Planning Application - WA/48/14/PL

Regarding this planning application, please find below details of our objection.

Proposed Site Layout

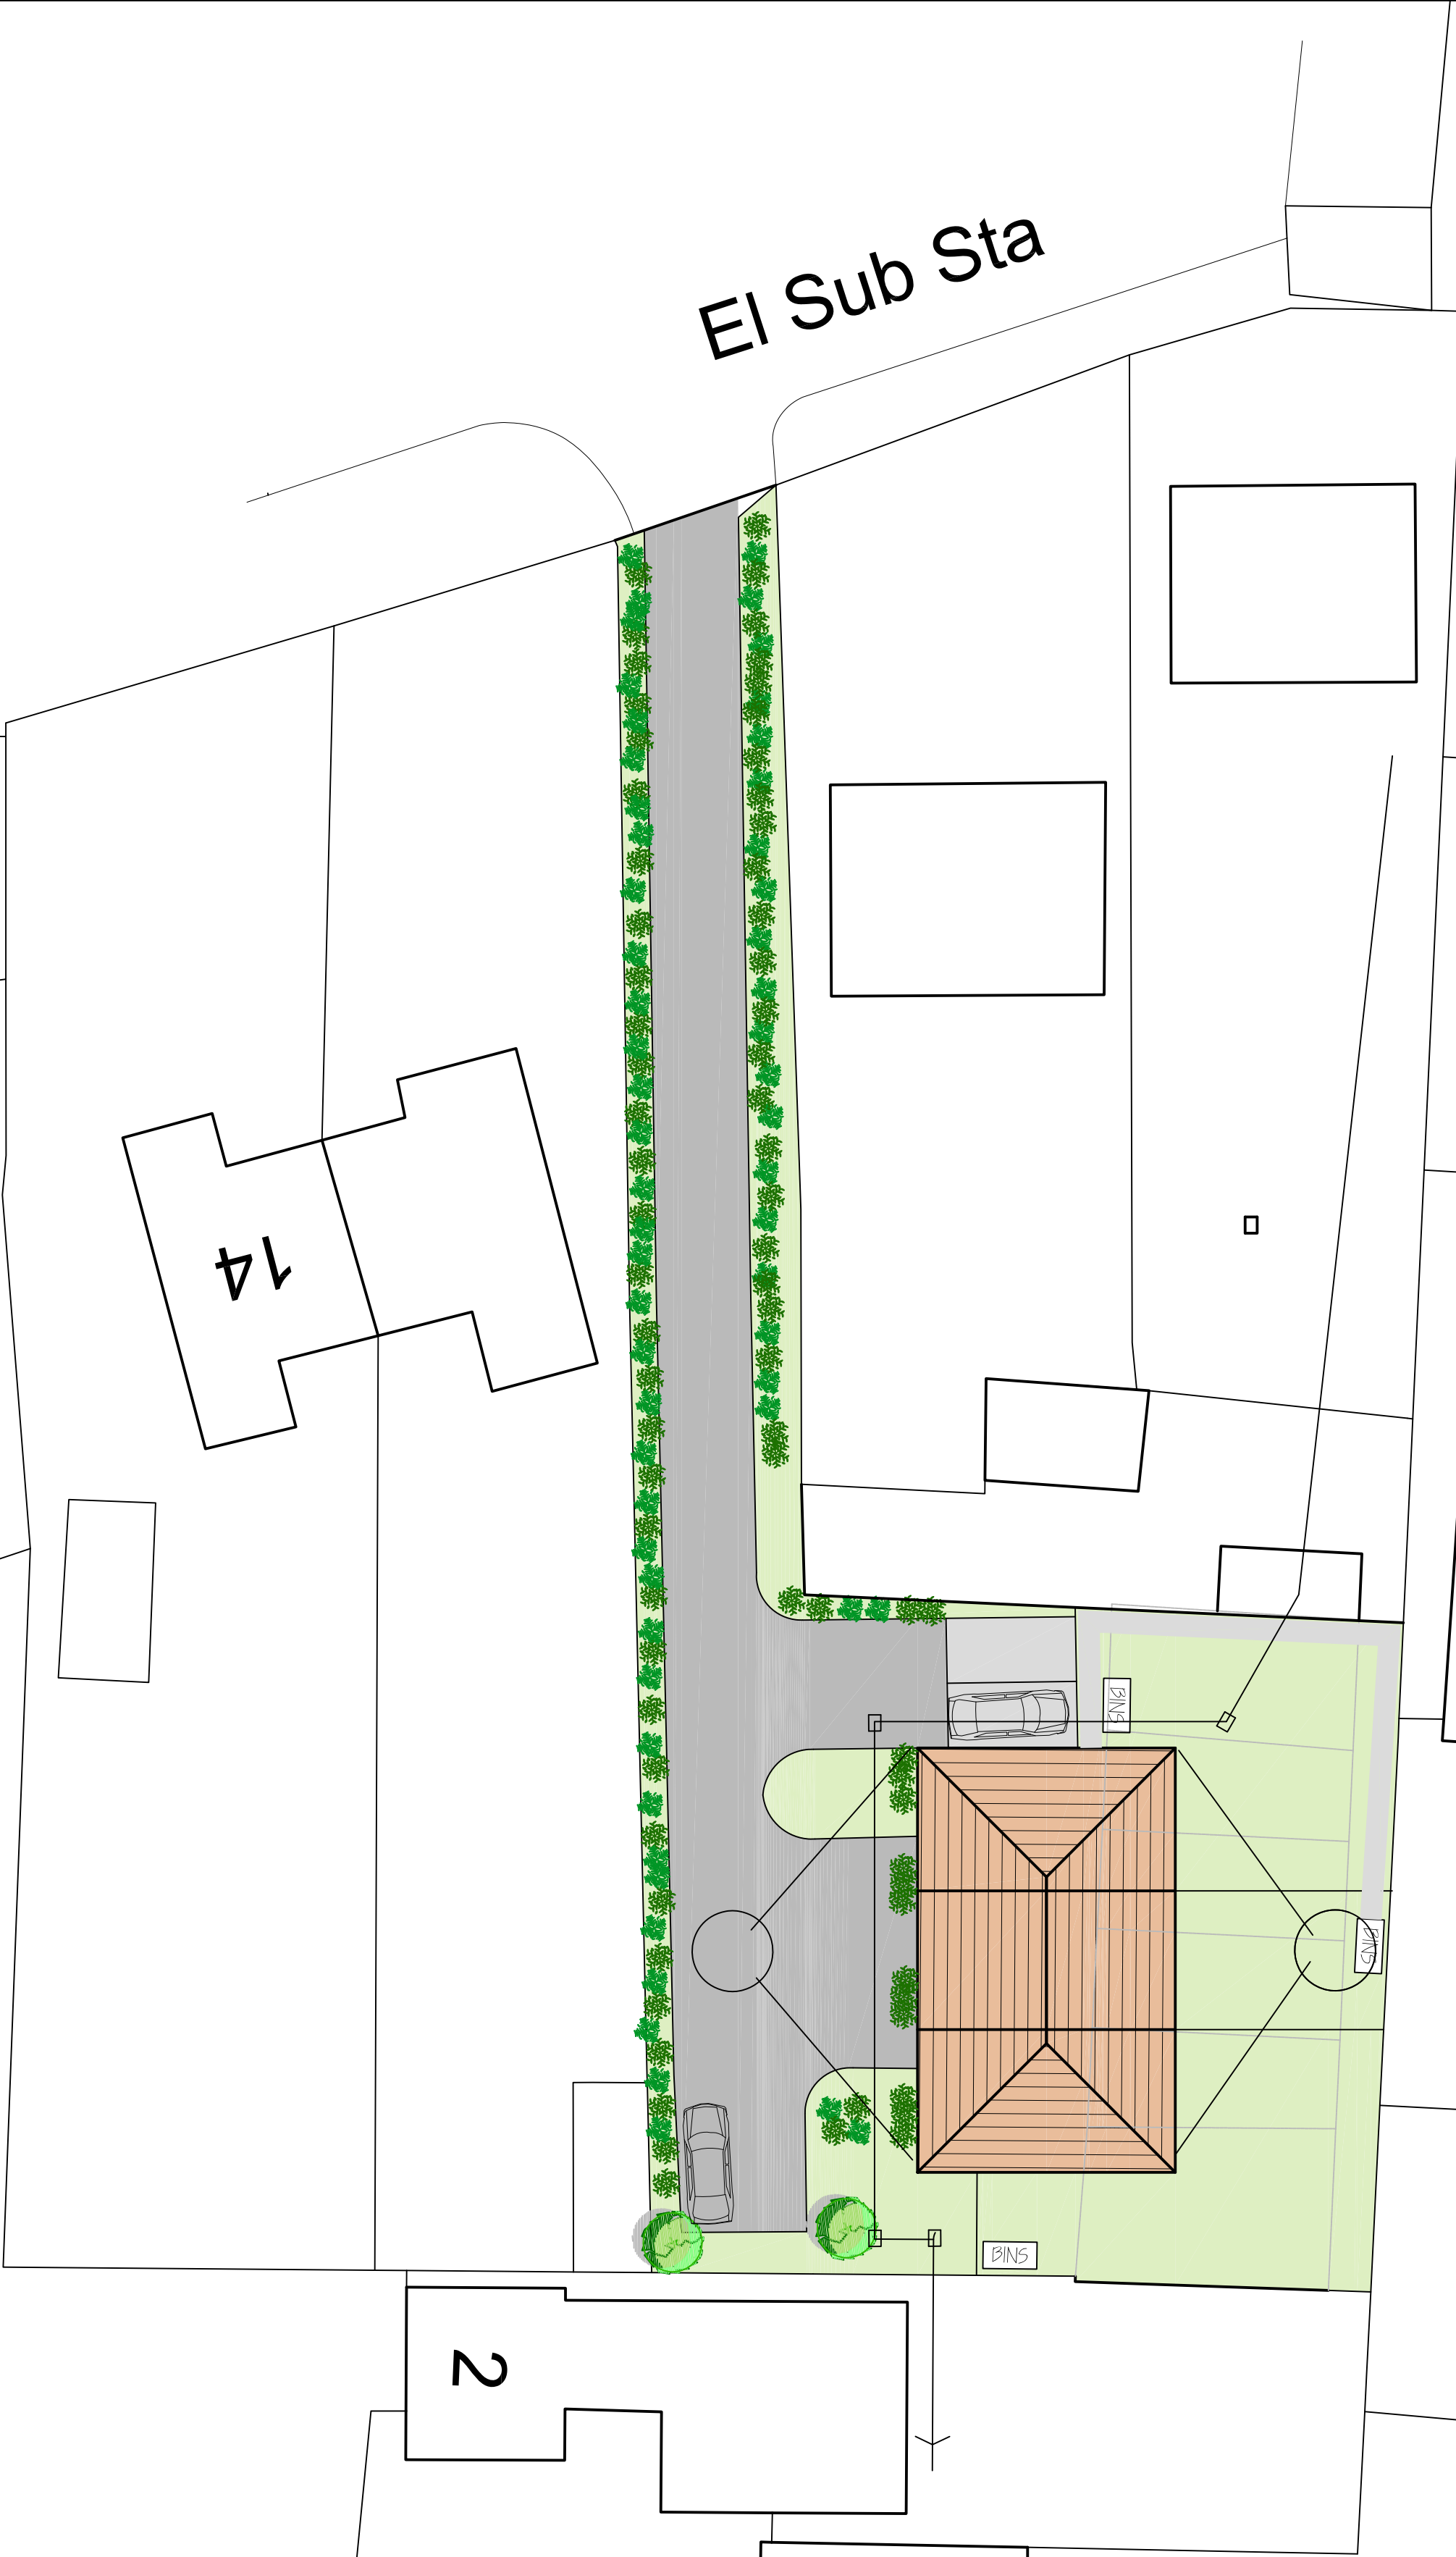
The plans show parking for 4 cars, but doesn't take into consideration most households have 2 cars. Therefore there would insufficient turning or parking space, and definitely no room for visitors or delivery vehicles.

- Outside our garage, we have a section of hard standing and double gates. There are also parking spaces within our deeds outside of these gates. With the proposed structure of the properties, it looks as though there will be a divide between that area and the new house parking spaces. With this divide we lose sufficient turning area to be able to drive in or out. Therefore making our parking to the rear unusable and effectively redundant. Again completely unacceptable.

Proposed Layout & Elevations

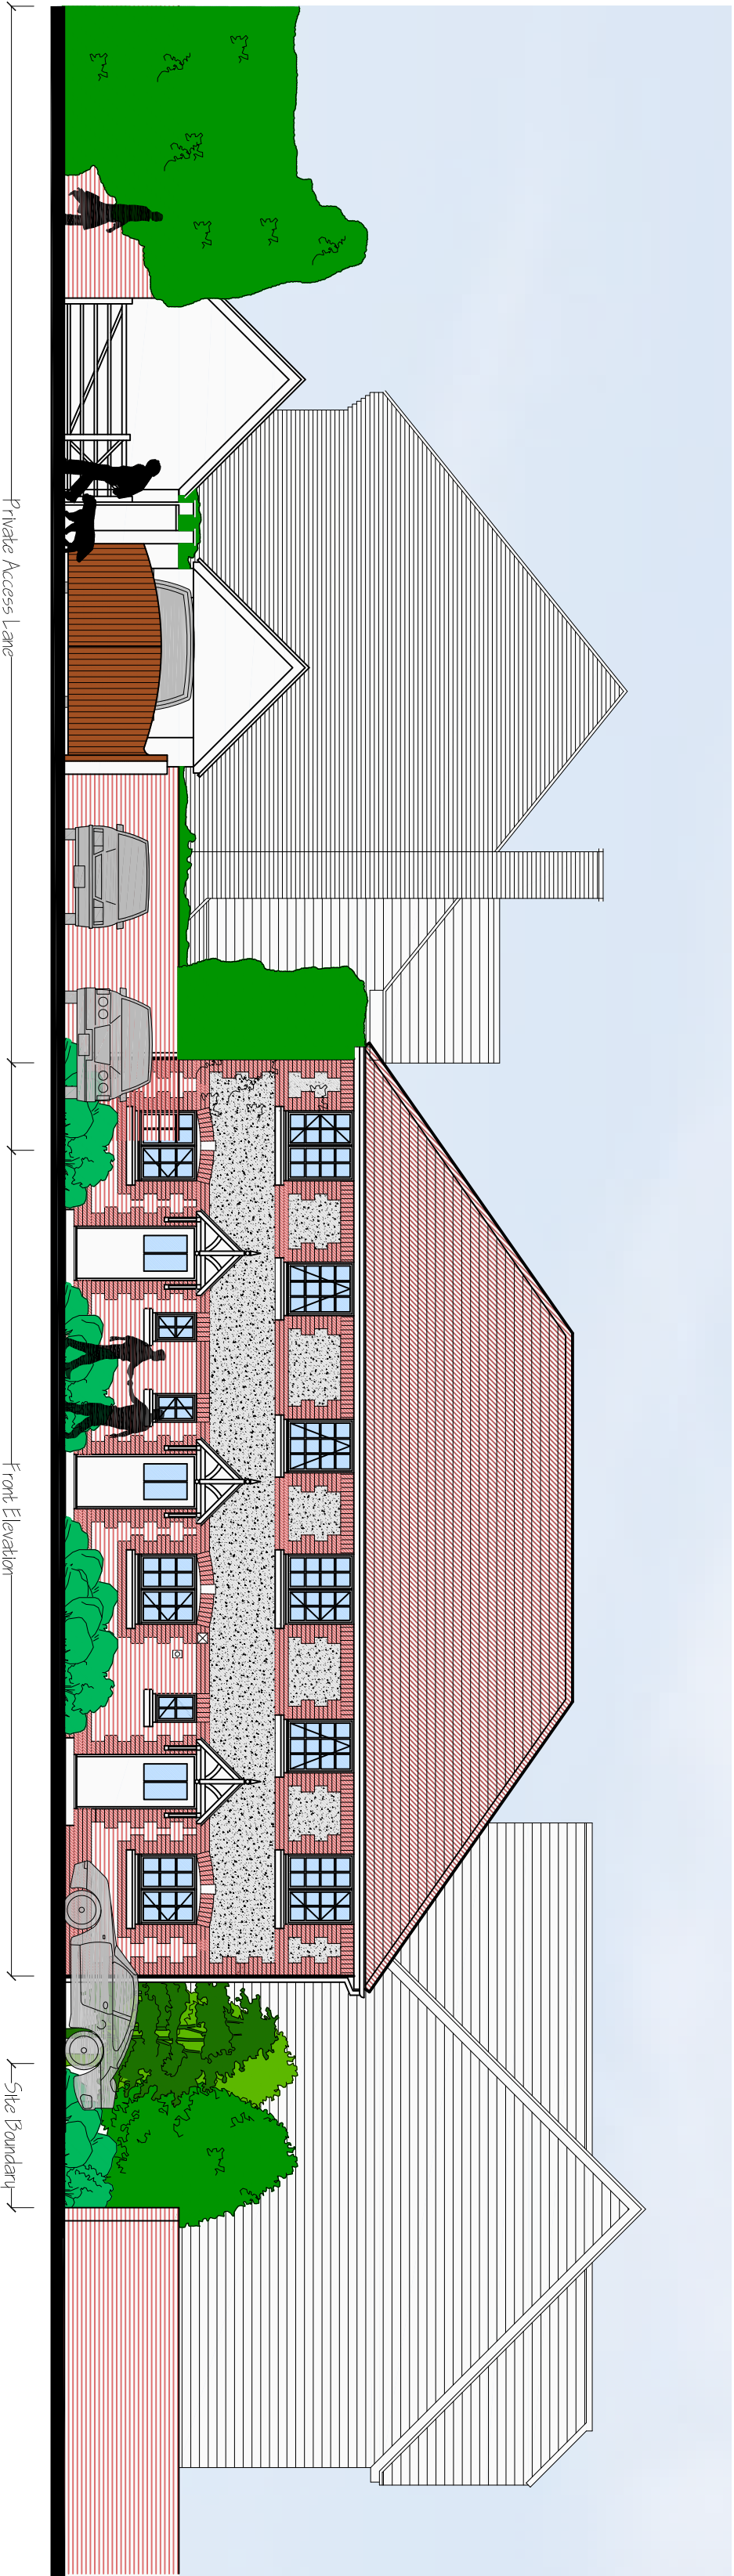
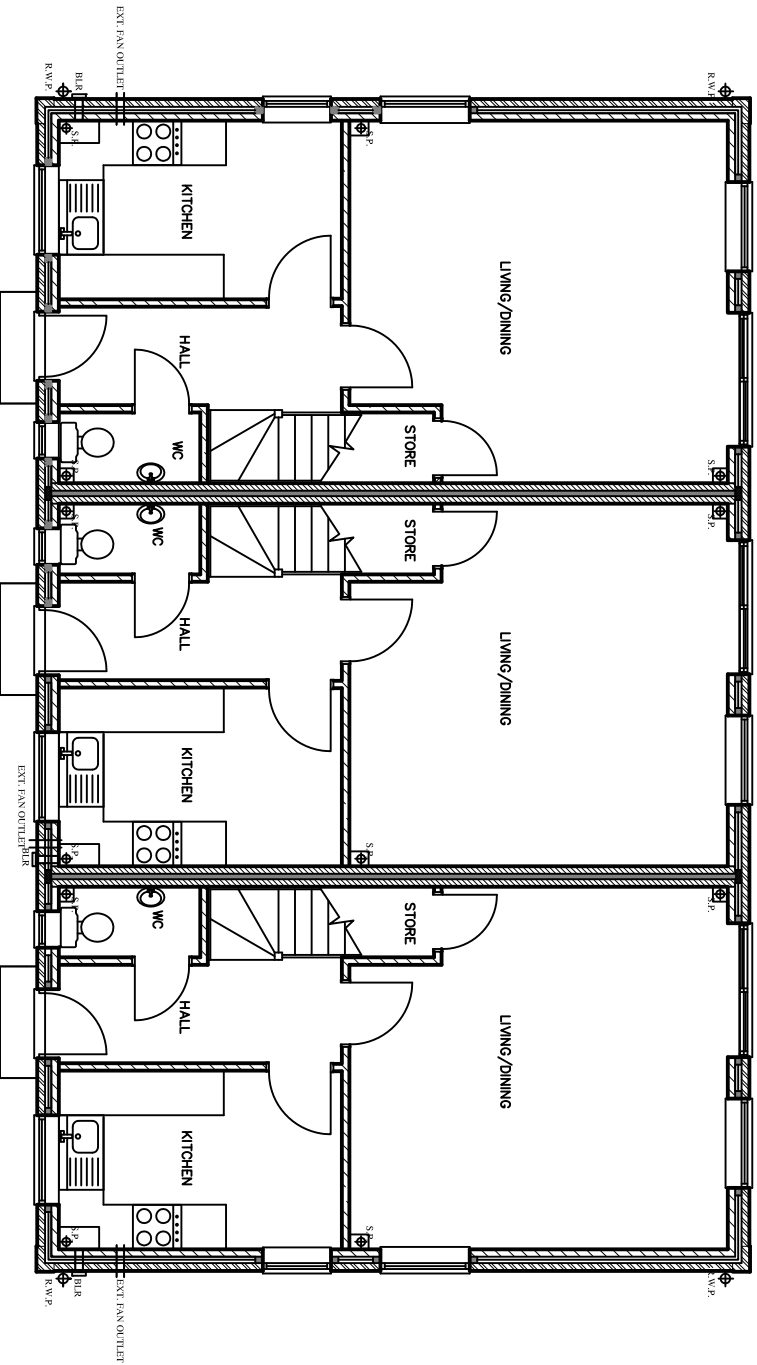
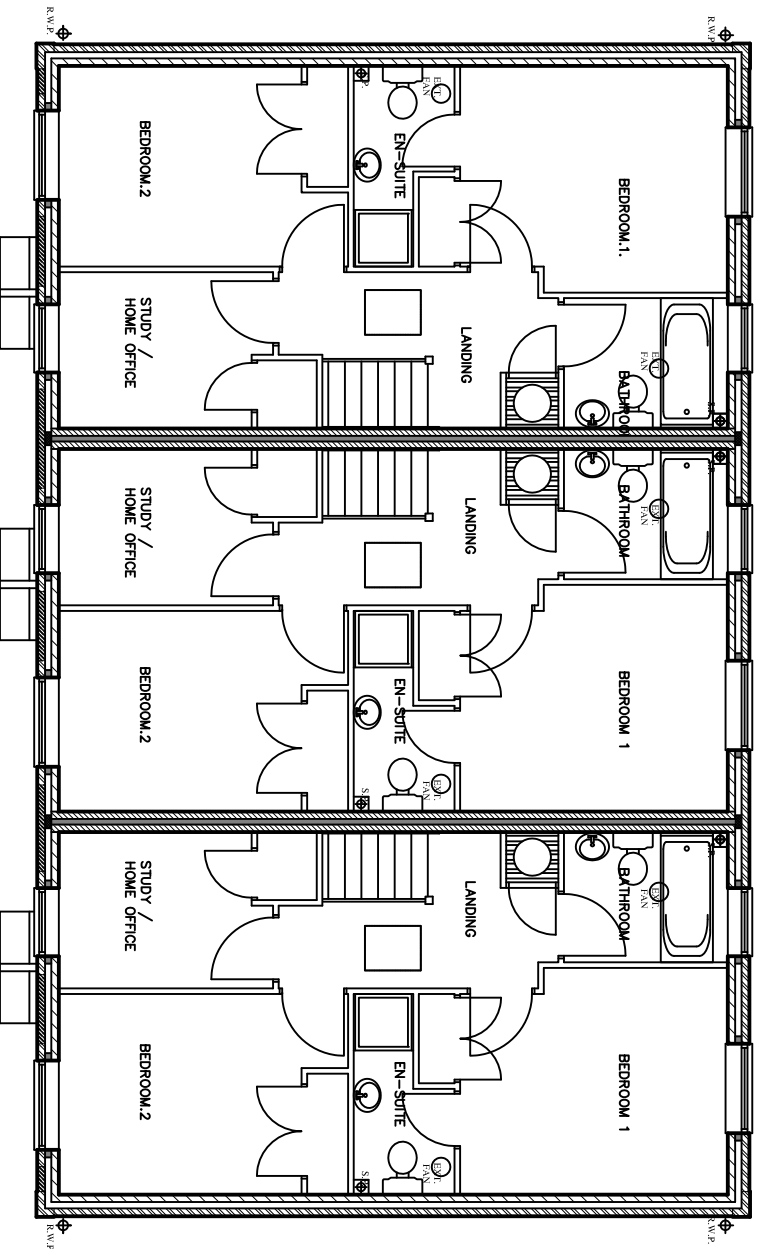
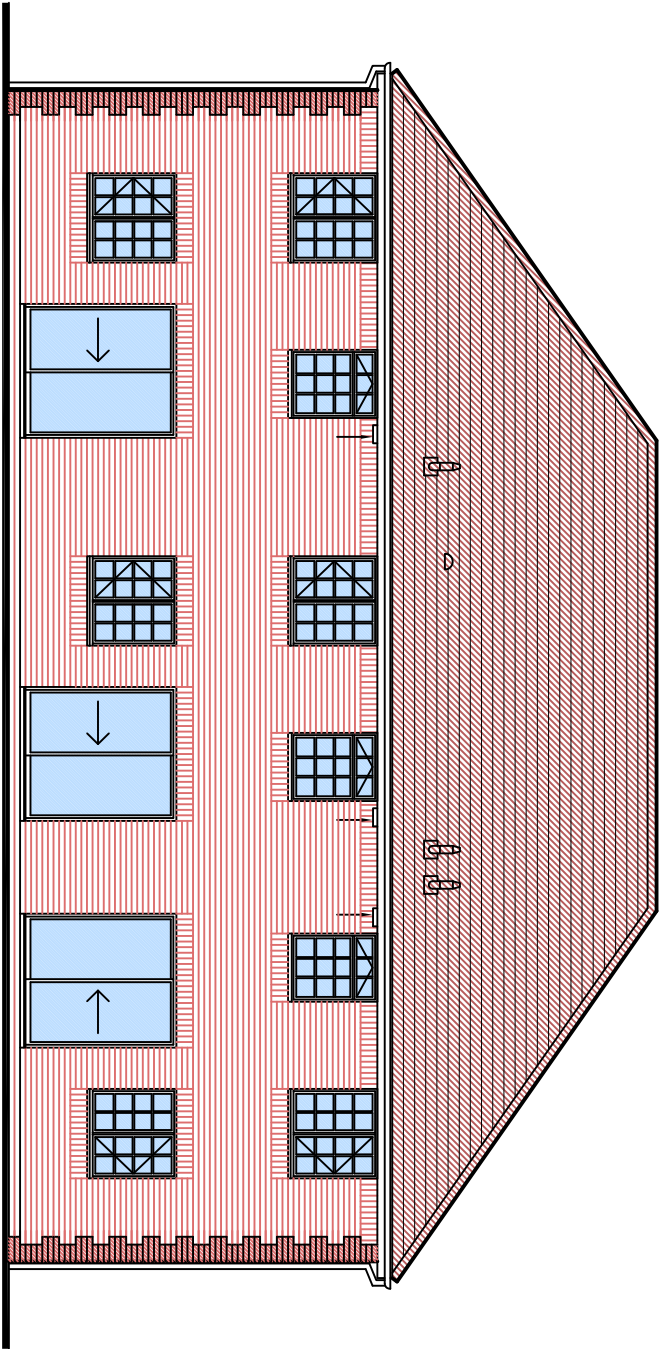
We are surprised that the owner is still proposing building 3 houses on such a small plot. We have looked at the plans, and the size of the properties, along somewhat altered, are still very small and not in keeping with the area.

- By having a 2 story property at the rear, although not overlooked by windows, our sunlight in the winter months will be greatly affected.
- Our garage wall is currently attached to the units. Our solicitor has advised legal approval from us would be required prior to any building work being carried out as it is an adjoining wall.
